# **Annex 1 to Submission by North Somerset Council in respect of Action point 19 ISH 5 -Environmental matters**

## **March 2021**

Following receipt of the cross-sectional details of the proposed Trinity footbridge North Somerset Council as Local Planning Authority considers that in relation to the impacts of overbearing impact and adverse visual impact these may be slightly less severe than we had feared previously

Figure 7: 21st June 2pm

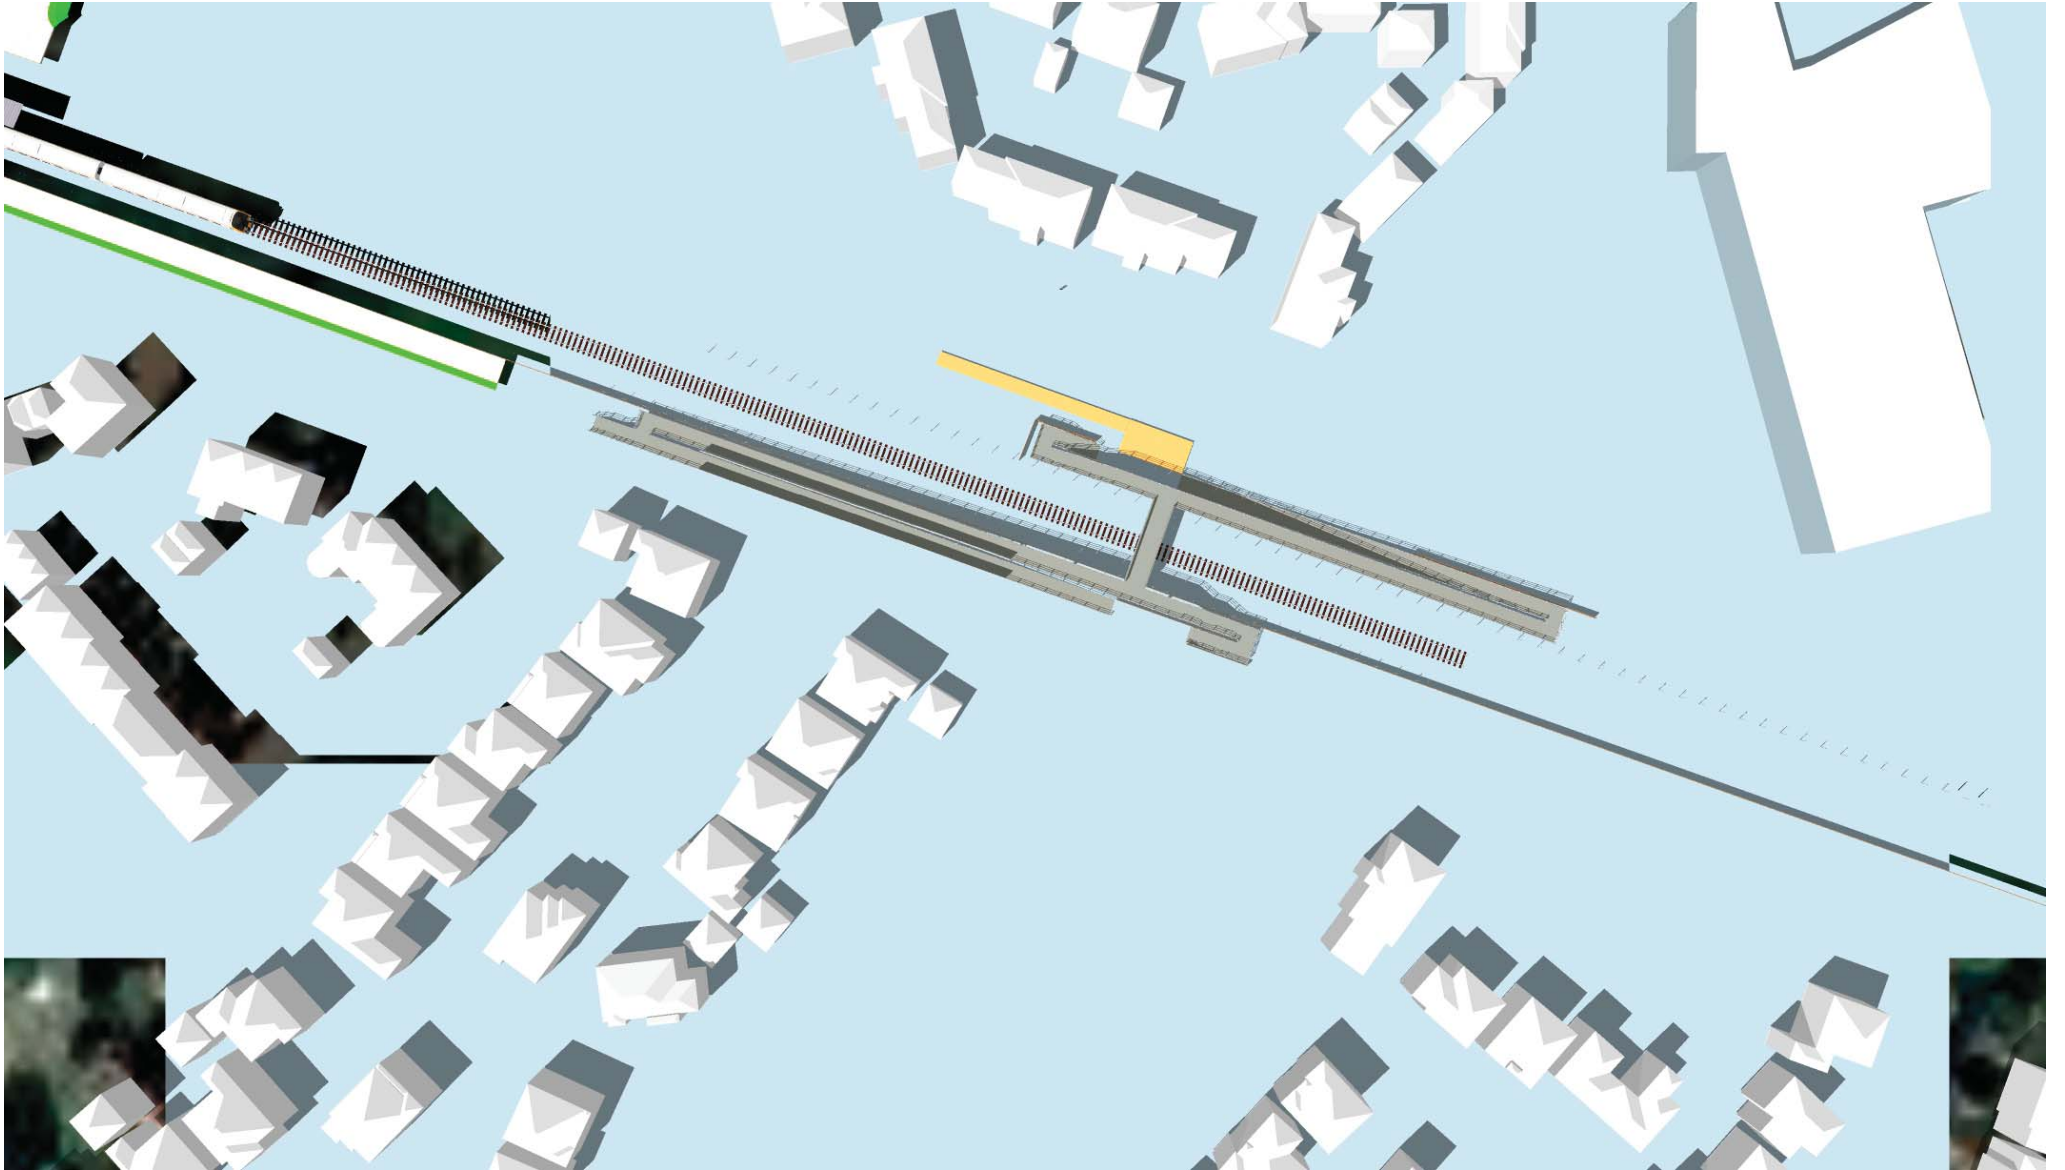
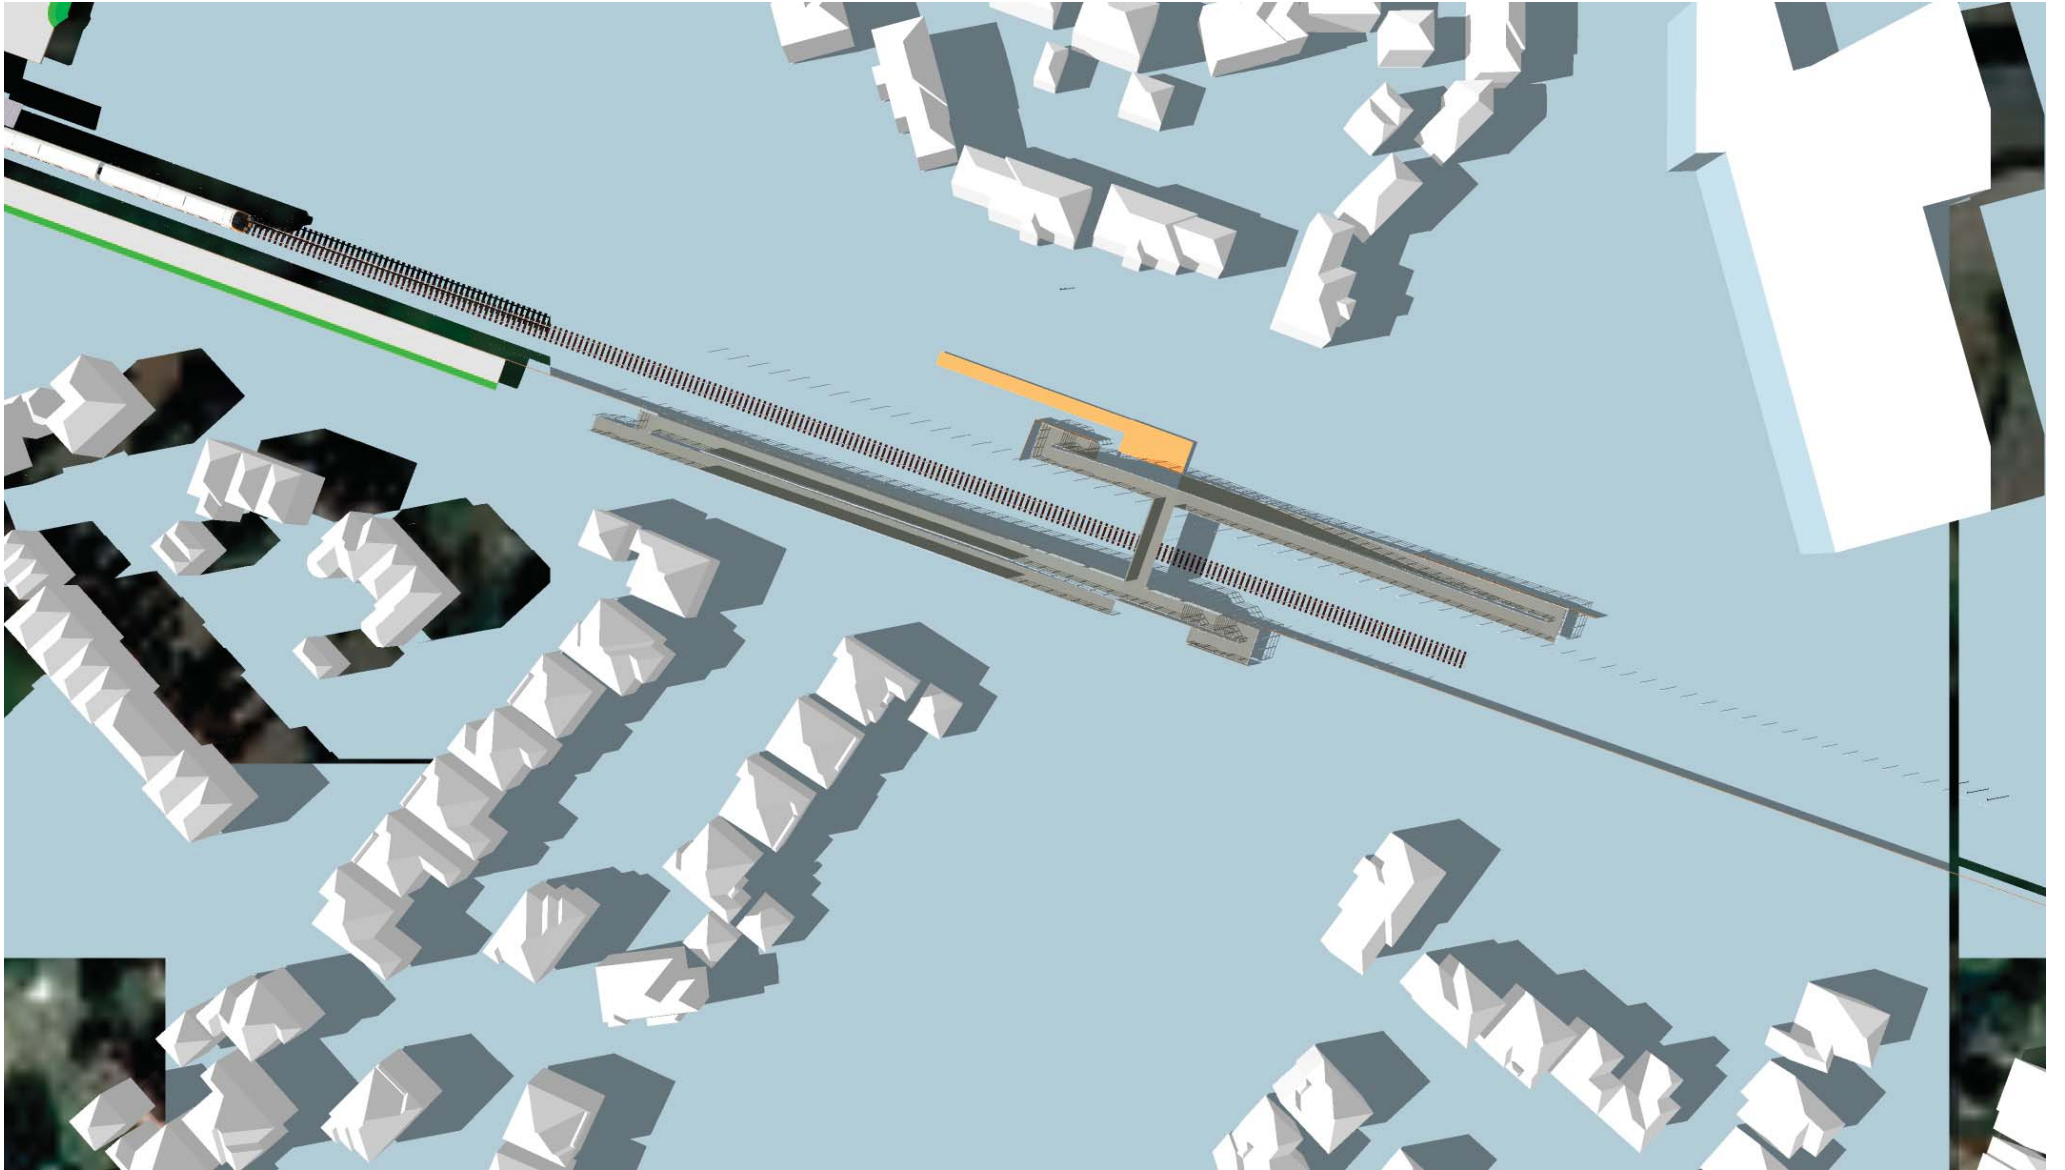
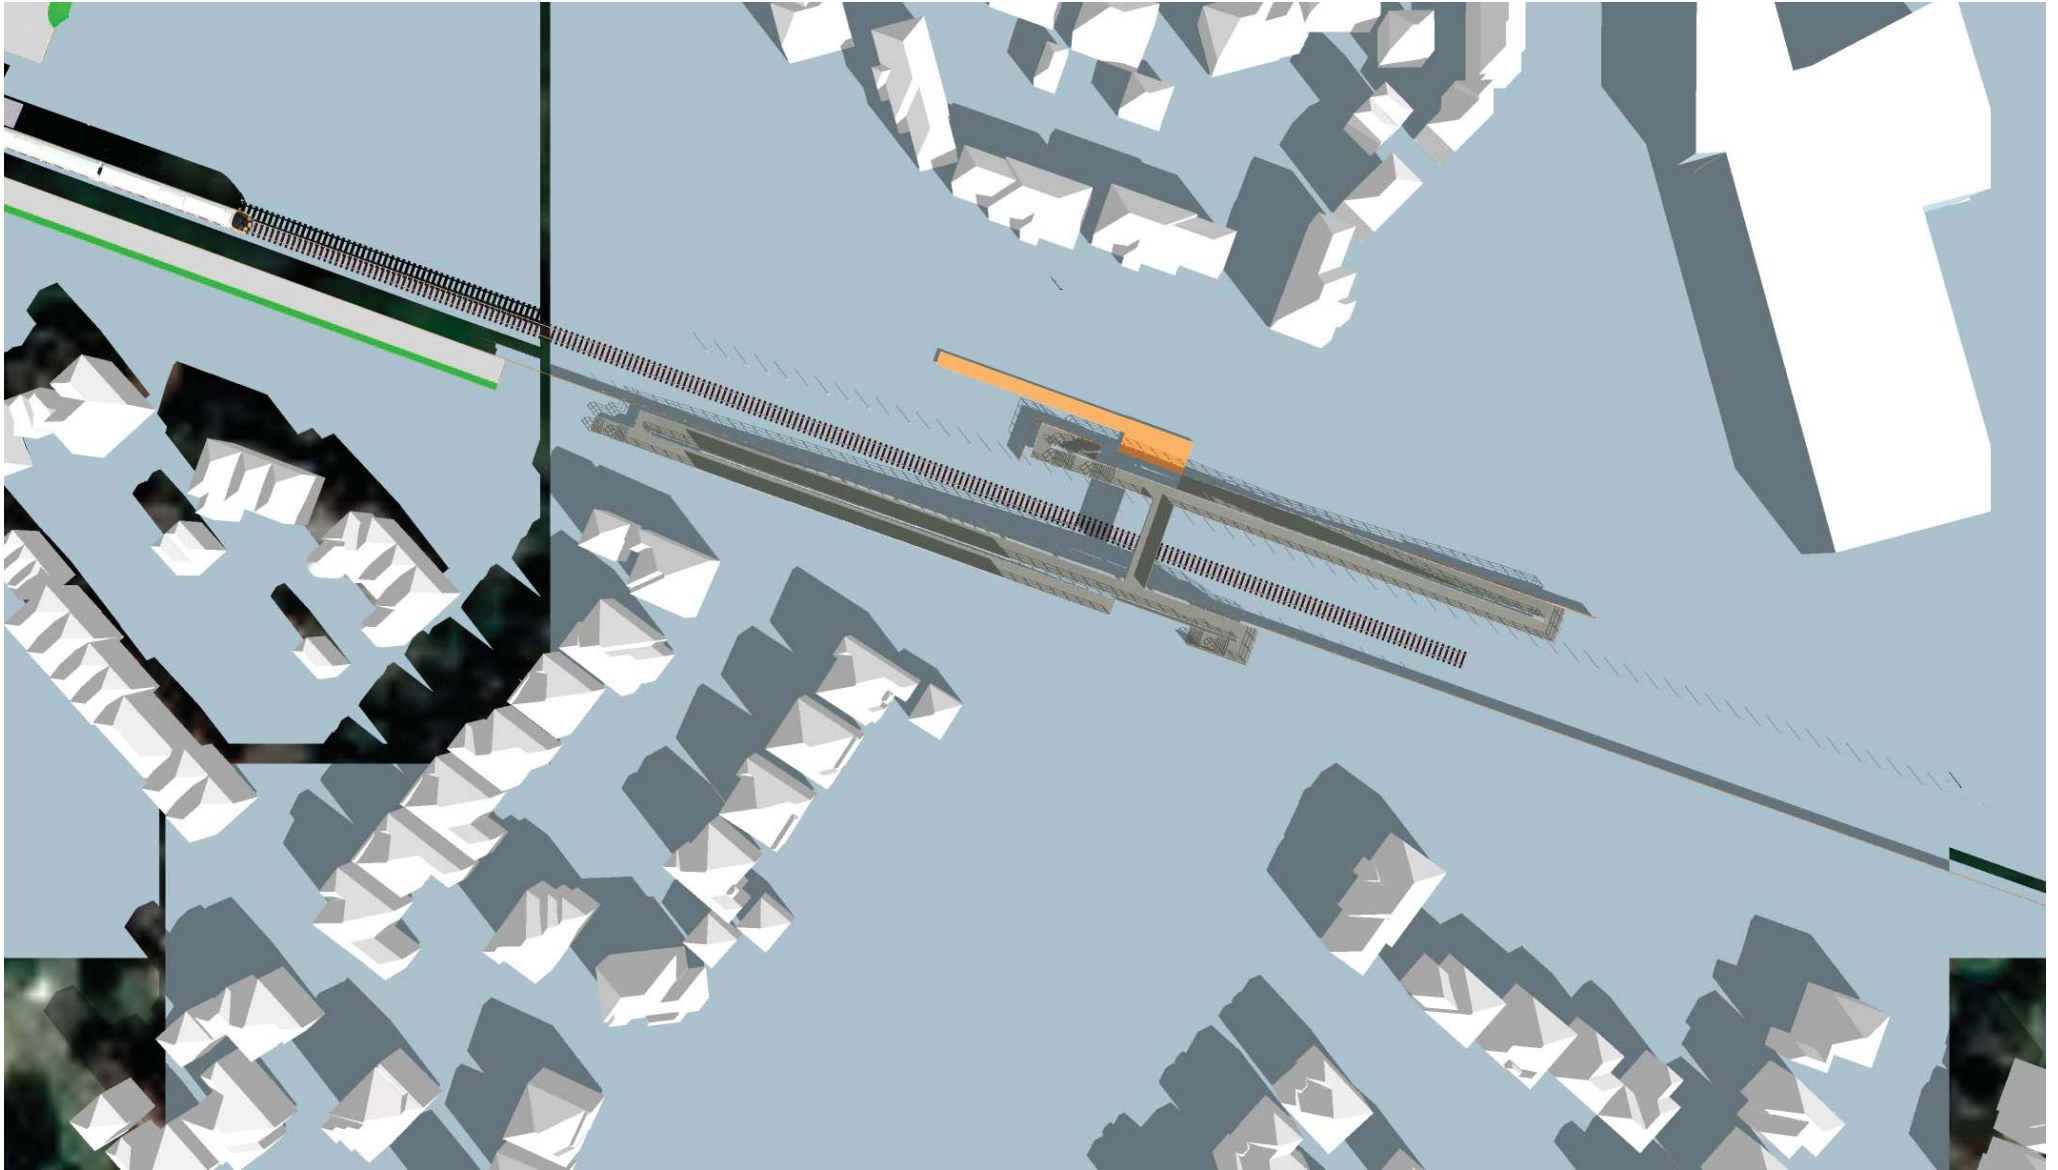
Following receipt of the shadow diagrams it is now easier to assess the impacts that these structures will have on surrounding properties.

The study presents shade impact graphics at 10:00am, 12:00am, 2:00pm and 4:00pm during Spring Equinox, Summer Solstice, Autumn Equinox and Winter Solstice. We consider that this provides sufficient information. From this information, it appears that the footbridge structures have the *potential* to overshadow properties along Tansy Lane (No 9, 11, 15 in particular) rather than properties to the south of the bridge.

From these graphics, it appears that these structures would have no impact at most times and periods of the year on these properties, except for the Winter Solstice
